Submission for The Albion Park Rail bypass

# Map 3 - Southern Interchange

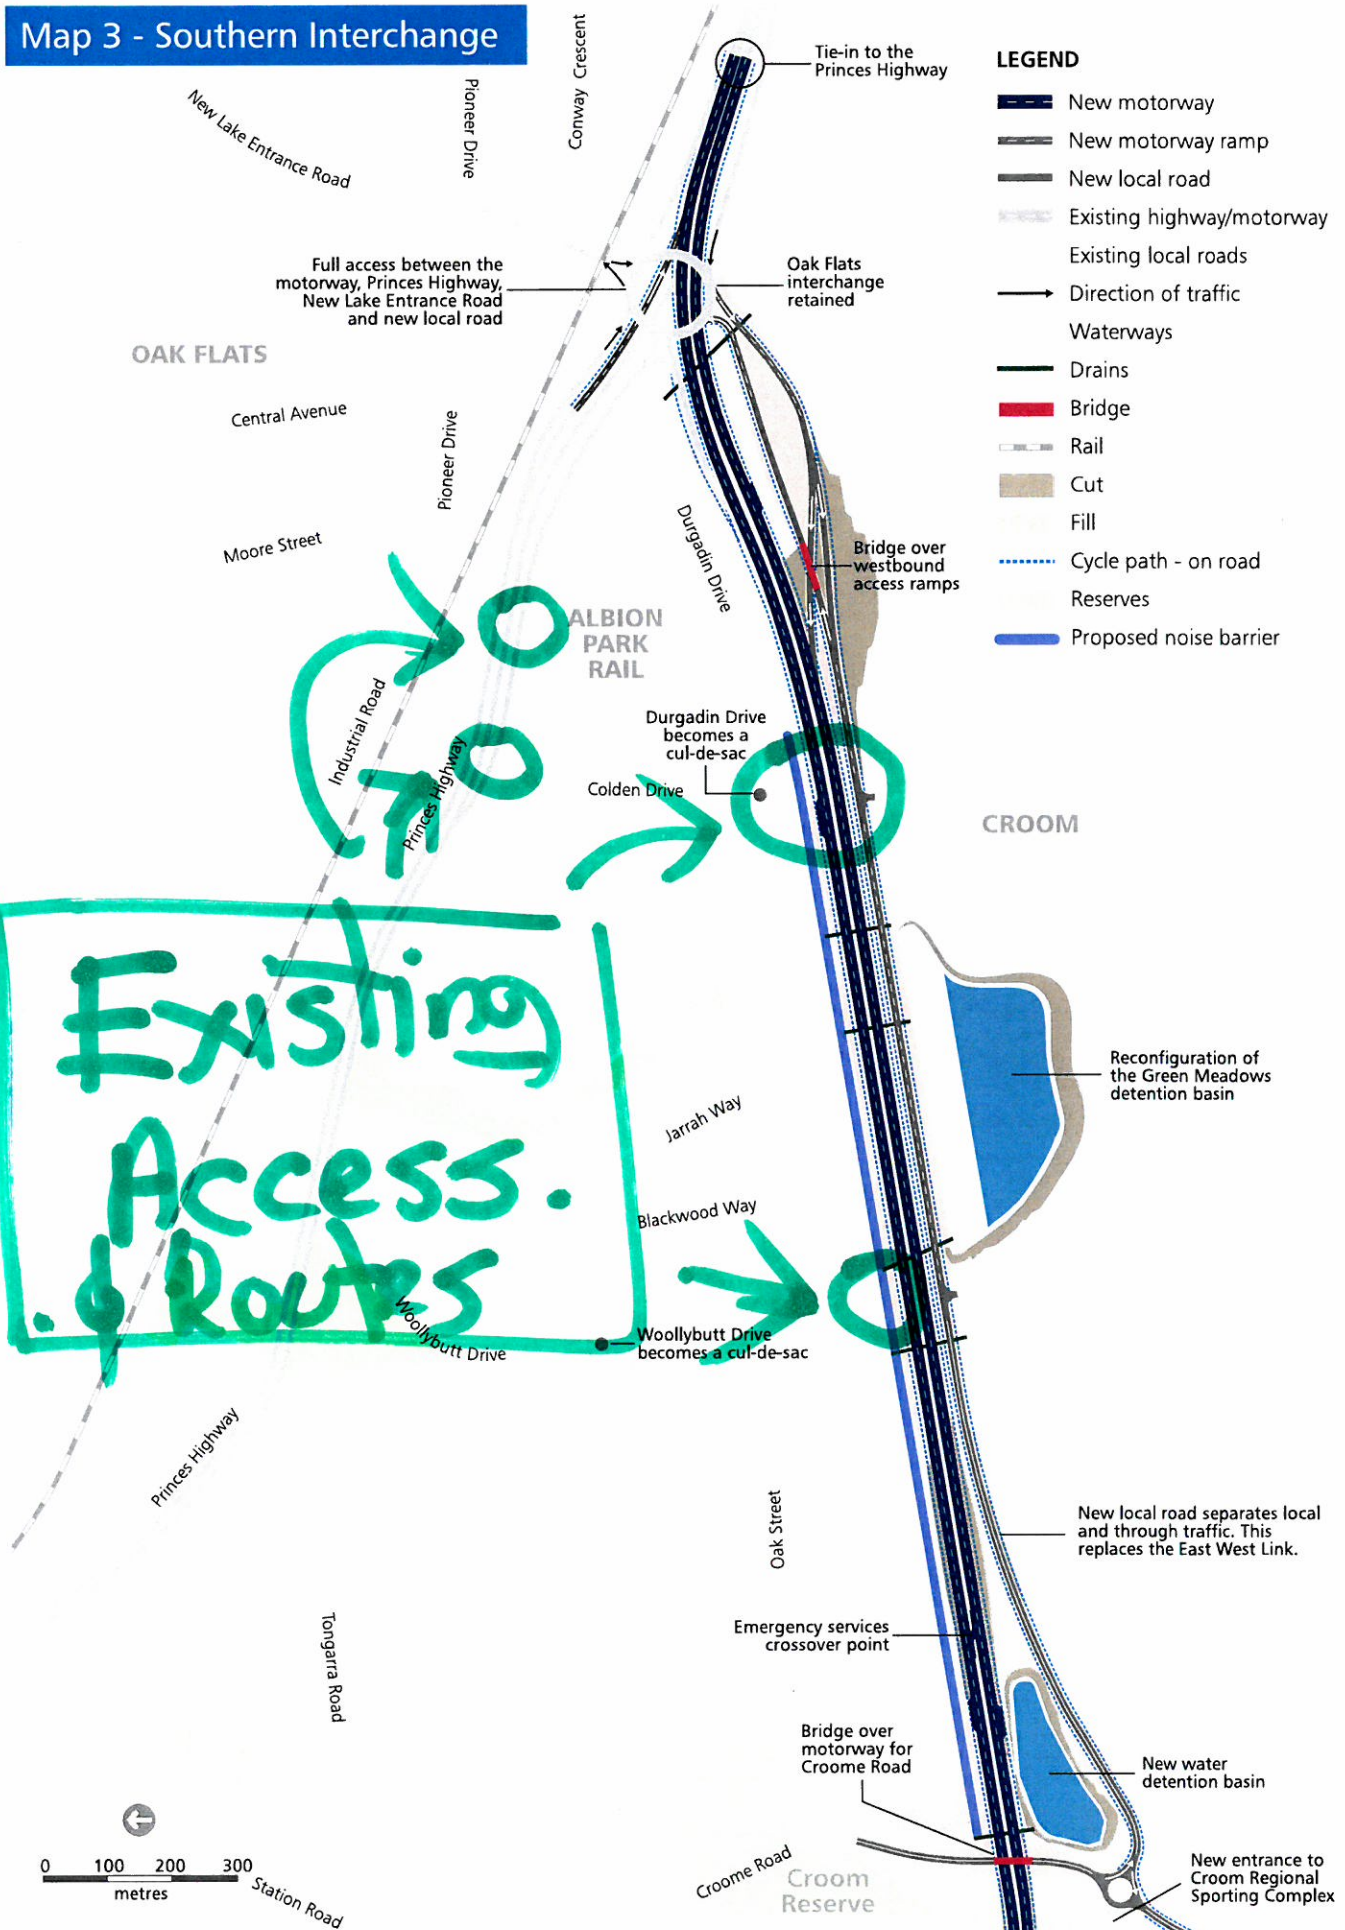
This has been planned east of the current alignment of Croome Road, bringing this piece of infrastructure closer to residents and changing the current alignment of Croome Road to the north of the round-about (which requires the removal of old, well established native trees that help to form a visual and sound barrier to the Croome Road traffic). Also, this easterly positioning moves the *elevated* Croome Road Bridge (BR12), closer to residents and impacts on the current character of Croome Road, removing its gentle curves through a wooded area just north of the Croome Sporting Complex entrance.

I propose that the position of the round-about is reconsidered, so the road alignment remains in its current position. I understand that this may impact on construction logistics and traffic management but the neighbouring residents are here for years to come and a little inconvenience for others, in the short term, is a small price to pay.

As mentioned in Point 1, the proposed new alignment of Croome Road moves the bridge closer to residents. By maintaining the current alignment of Croome Road, it would keep the bridge that much further away. The road from the new round-about to the bridge and on to the northern side of Croome Road will now be elevated to meet the required height over the new by-pass, well above Croome Road's current level (ref. Design & Landscape Character Strategy Page 74, Diagram 21), increasing both visual and noise pollution to local receivers.

- a. Maintaining the current alignment of Croome Road, to push the bridge infrastructure further away from local residents.
- b. Noise barriers installed along the eastern side of the bridge and elevated section to the north along Croome Road. Although noise barriers add to the visual pollution, I would rather the 24/7 noise pollution be reduced at the expense of the occasional visual blight.

From the new round-about on Croome Road heading east, the new East West Link Road is positioned up the hill and, looking at the EIS diagrams, it appears to be elevated with fill material at this point. Vehicles accelerating and decelerating as they approach/leave the round-about, will throw additional noise pollution across to local receivers.

- a. Construction of an earth mound on the northern side of the East West Link Road at this point.
- b. Quieter Pavement along the full length of the East West Link Road, given its elevated position. (It seems strange that the by-pass is to have quieter pavement along this section because of the close proximity of residents but the busy East West Link Road does not).

I propose these 2 ancillary sites should be combined and either moved further east, along the East West Corridor or into the Croome Road Sporting Complex. These sites will produce noise and air pollution from engines starting up, reversing alarms, workers talking/shouting, dust etc. Consideration should be given to relocating AS12 & AS13.
